From: Laura Gibbons
Sent: 21 February 2019 15:56
To: 'Katherine Jenkins'
Cc: Andrew Wood
Subject: RE: Planning Application FG/220/18/PL : Land adjacent to Elm Lodge, Tamarisk Way, Ferring, West Sussex BN12 5ER

Laura Gibbons, MEng, GMICE
Engineer (Drainage & Coastal)

1. Please identify whether a pipe exists at the western extent of the pond. This will impact upon if I believe there is a likelihood you will have sufficient space for surface water drainage. The soakaway that you are currently proposing is located directly on top of the suspected pipe location. We will be able to identify the location of any potential pipe as part of a pre-commencement condition. We agreed that we could also submit details of proposed soakaway locations as part of the pre-commencement conditions relating to surface water drainage, once potential for soakaways had been adequately assessed, calculated and positioned by a civil engineer. It is likely the 100mm diameter soakaway pipes would be at a higher level if crossing over any existing pipe from the pond, therefore may not impact any existing pipe, although we would ensure this is checked by a civil engineer and approved by ADC as part of the pre-co

Drawing Title **PROPOSED POND ACCESS
PLAN**

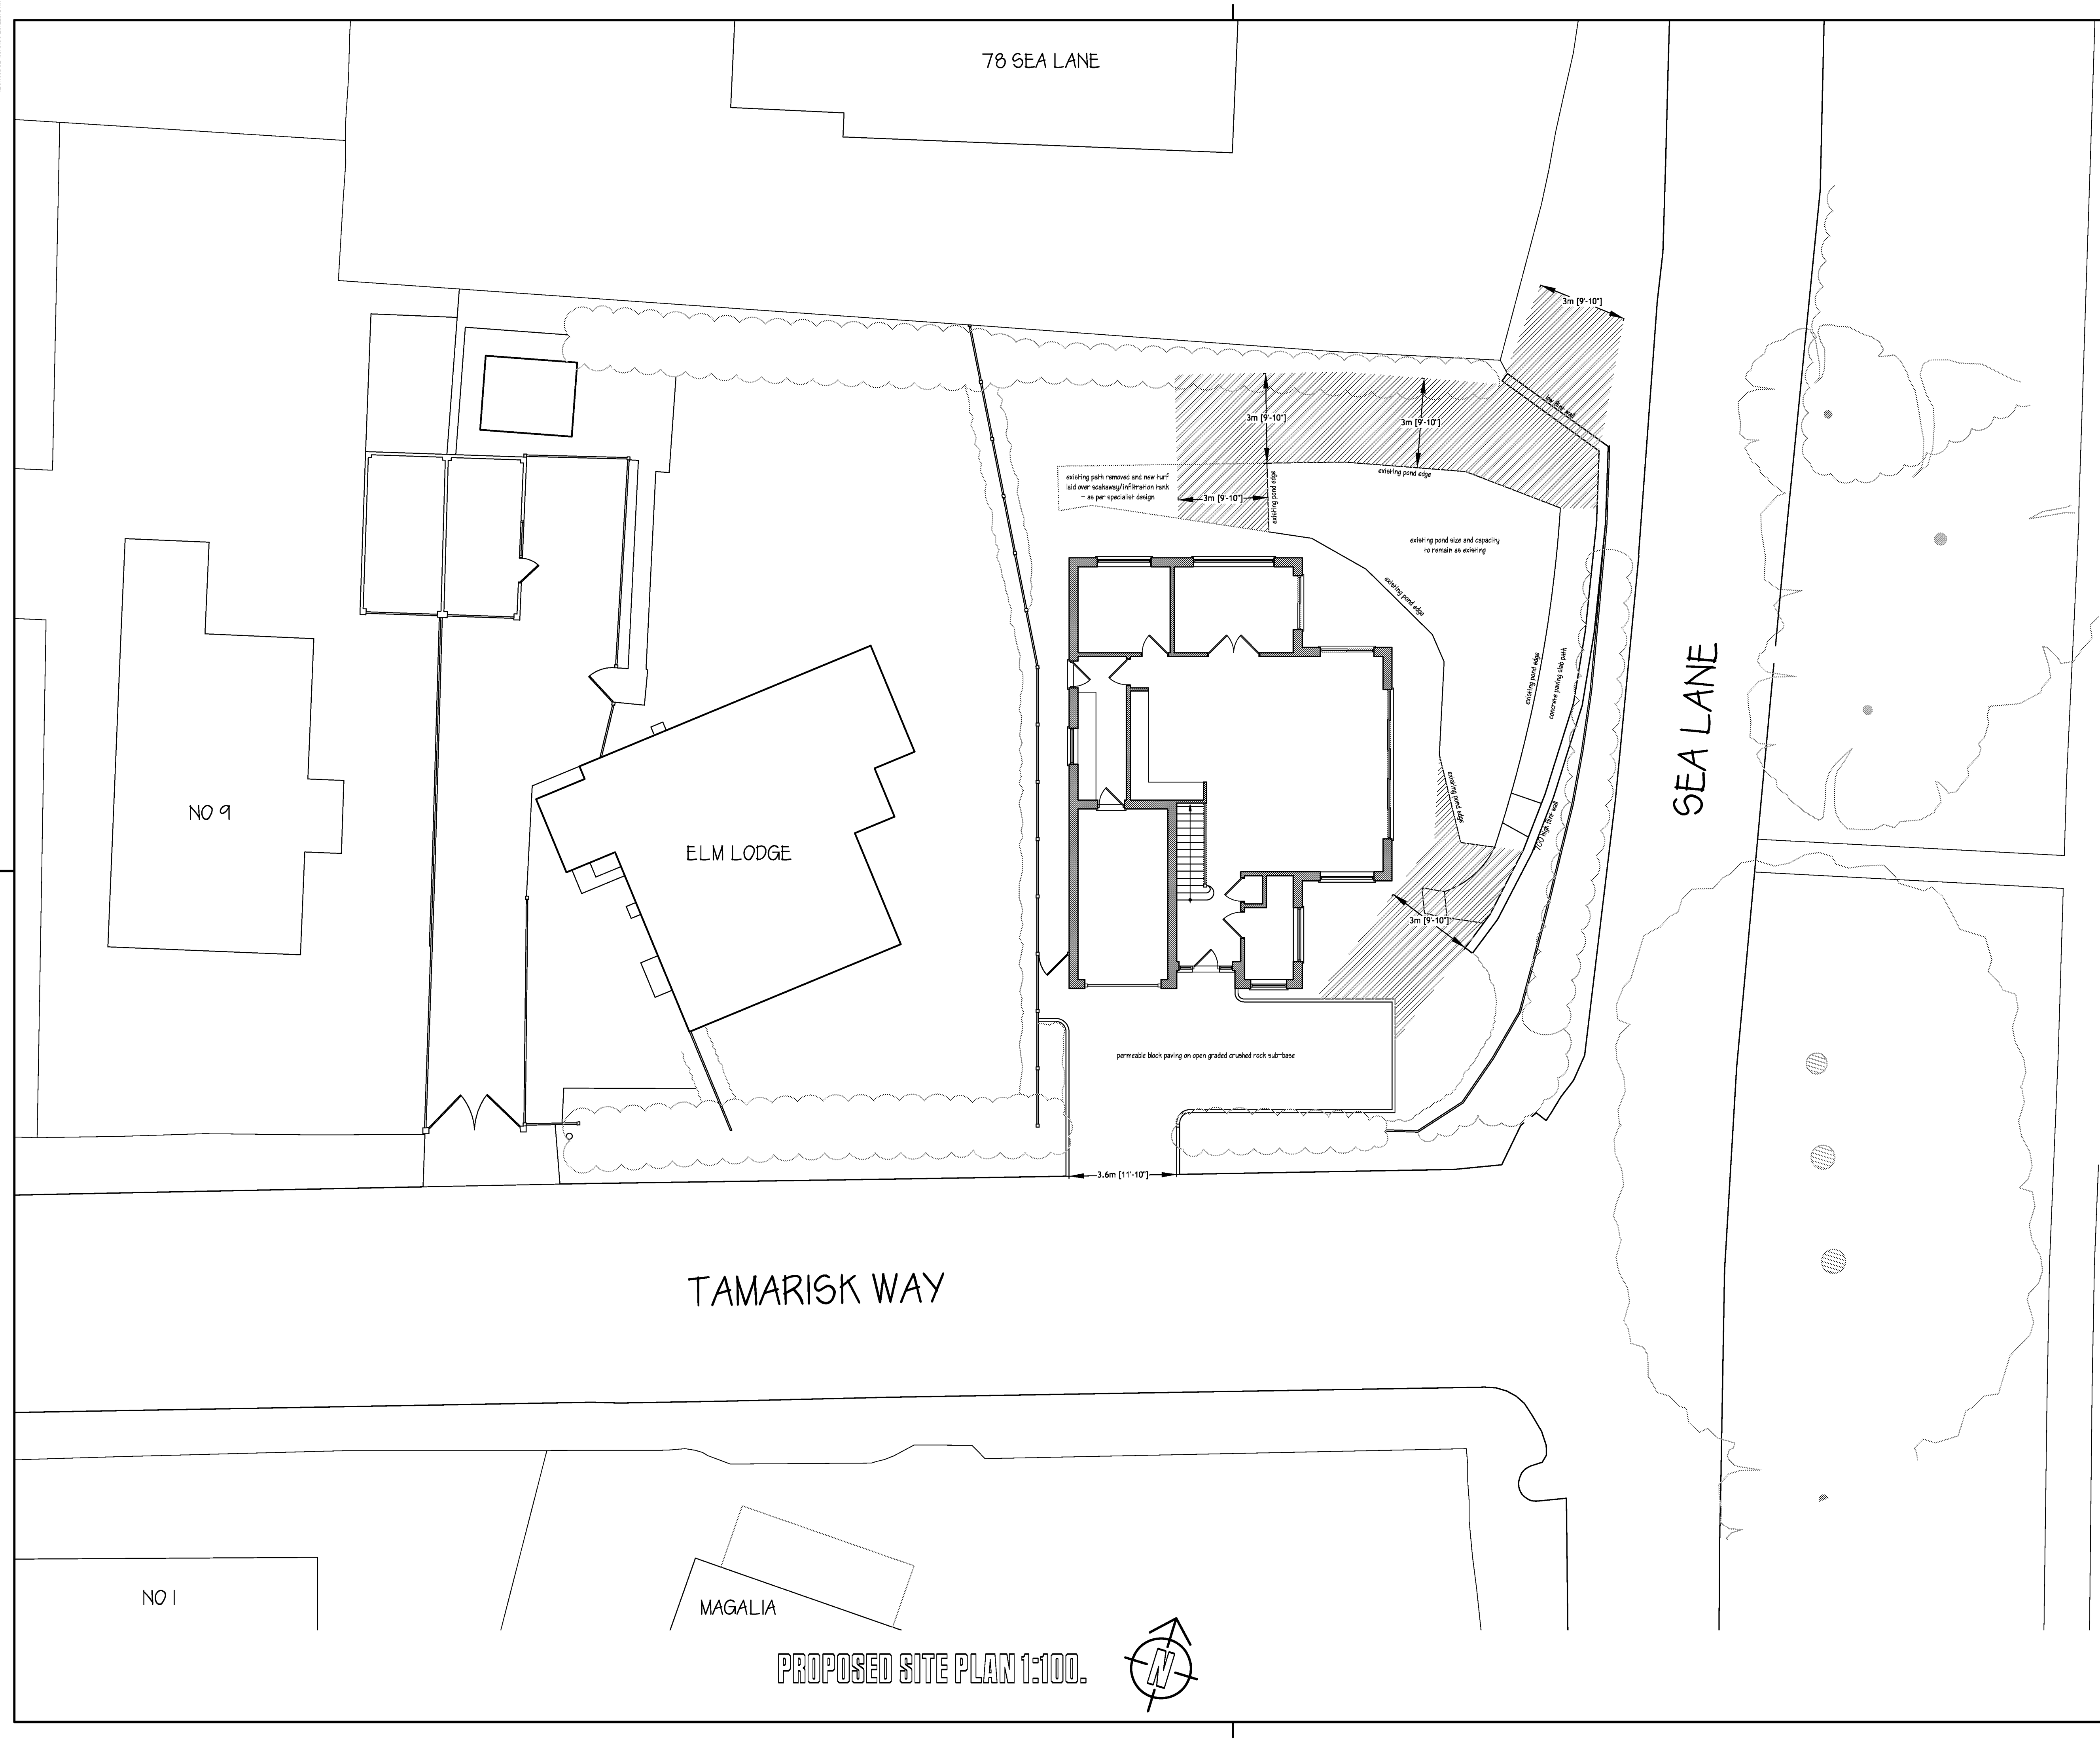
2. I am not keen to see the building go up to within 0.8m of the pond. Access and erosion are both a concern. I would therefore be keen to see the building layout revised to provide more easement. As shown on the proposed indicative part foundation section detail, short bore piles would be positioned a minimum of 3m from any edge of the pond, reducing the risk of erosion by eliminating trench foundations. Given a specialist would be designing the reinforcement/camp shedding for the existing edge of the pond (again, to be agreed with ADC by condition prior to commencement), this would ensure there will be no erosion. Given the building would only be cantilevered at one point within 0.8m of the pond, there is still a large area of access around the east and all other parts of the pond. We note that ADC has never had to access the pond to carry out any maintenance works to date, therefore query why there is such an onerous requirement for access now. We also note that ADC cannot currently access the pond with plant, since we have gates to the property and a further gate at the rear which would obstruct machinery from accessing our garden to carry out any maintenance works at all. ADC would have greater access to the pond as a result of the proposal, given there would be no obstruction when entering from the driveway. ADC Bylaws state that "Riparian Owners are responsible for maintaining the watercourse and any associated structures (i.e. headwalls, screen, weir etc.) and primarily to keep them free of any obstructions that may impede flow in the watercourse". There will be no obstructions which impede the flow in the watercourse, as demonstrated. We can easily complete any pond works to ensure it is upgraded from its current state (which has not been identified as obstructed or badly maintained by ADC to date) before commencement of any building works on site. The bylaws state that "Arun District Council may decide to exercise the permissive powers if it is approached by property owners affected by badly maintained or obstructed watercourses and they have been unable to get a 'riparian owner' to carry out necessary works. In the first instance, Arun District Council will try to resolve the problem informally by explaining 'riparian ownership' responsibilities and agreeing the work that is required to the watercourse to rectify the problem. If this approach is unsuccessful, Arun District Council may require and enforce 'riparian owners' to carry out works using powers under S25 of the Land Drainage Act 1991 where the flow of water is impeded and the condition needs to be remedied." Given we as riparian owners will be able to access the pond from all sides to carry out any works in accordance with the bylaws, we do not understand why ADC would need access to our land, particularly from multiple different points given they cannot access it at all at present. It is the landowners (Riparian) responsibility to complete maintenance works, if we are informed of an impediment to flow we request landowners complete this maintenance. If they refuse to complete the work, we use our powers under S25, and this can be accompanied by forced entry through gates. The proposed layout will make it exceptionally difficult to complete maintenance. Irrespective of planning it is fairly evident that an impediment to flow is present, so we will be requiring you as landowners to complete maintenance to the pond to ensure silt levels are reduced and culverts are in an appropriate condition. Ongoing maintenance (including to any retaining walls) will be required after construction is complete, this is when the proposed site layout in my opinion would prevent this work.

3. It is my belief that there is no way to get to the northern and western portions of the pond without tracking through the pond itself. This would mean that maintenance would have to be completed in the summer by the landowner when water levels are lower. This would then be within nesting bird season. I would much prefer an access to be provided around the pond. I note that you state the 1m wide path to the east could take plant but this plant would not be big enough. As explained above, we as landowners can continue to access the pond from all sides, with 3m to the West, North and South East. We cannot understand what plant would ever be required (given no plant has ever needed to access the pond before, and any plant necessary for carrying out works to the pond can have full access from all sides as part of the building works) that would ever be larger than a small digger, which can easily be maneuvered up the 1m side access to the west of site and around the rear. You are going to need a large digger to access the pond and clear it of vegetation and silt. The size of machine is dictated by the depths that excavation need to be carried out to, the size of plant that can fit along a 1m path would not be sufficient to carry out the excavation required. Ongoing maintenance will be required after construction is complete, this is when the proposed site layout in my opinion would prevent this work.

4. It also needs to be demonstrated that the volume of pond to be infilled will be compensated for elsewhere. We will not be infilling the pond. The pond is to be retained as existing. The only part we are looking to change is the path to the west of the pond, which will have new turf added over the existing overgrown vegetation. This will not affect the volume of pond since there is no water in this area. We are happy for you to condition the application to ensure the pond is not infilled. In flood conditions the area that is currently used as a compost heap provides volume for water storage, this would be lost with your current proposals.

Further to our meeting at the land adjacent to Elm Lodge, Tamarisk Way, Ferring, West Sussex BN12 5ER on 12th February 2018, please find attached the existing and proposed pond access plans as requested. These show the existing pond to be retained in its entirety, with 3m access provided should Arun District Council ever need to access our property to maintain the pond. We hope these now alleviate your concerns regarding potential future access. We also note that the path to the east of the pond is also over 1m wide, which can currently comfortably accommodate a 1.5 ton digger to carry out any works. Given that there are multiple points of entry along the edge of the pond, any further work can be carried out from within the pond.
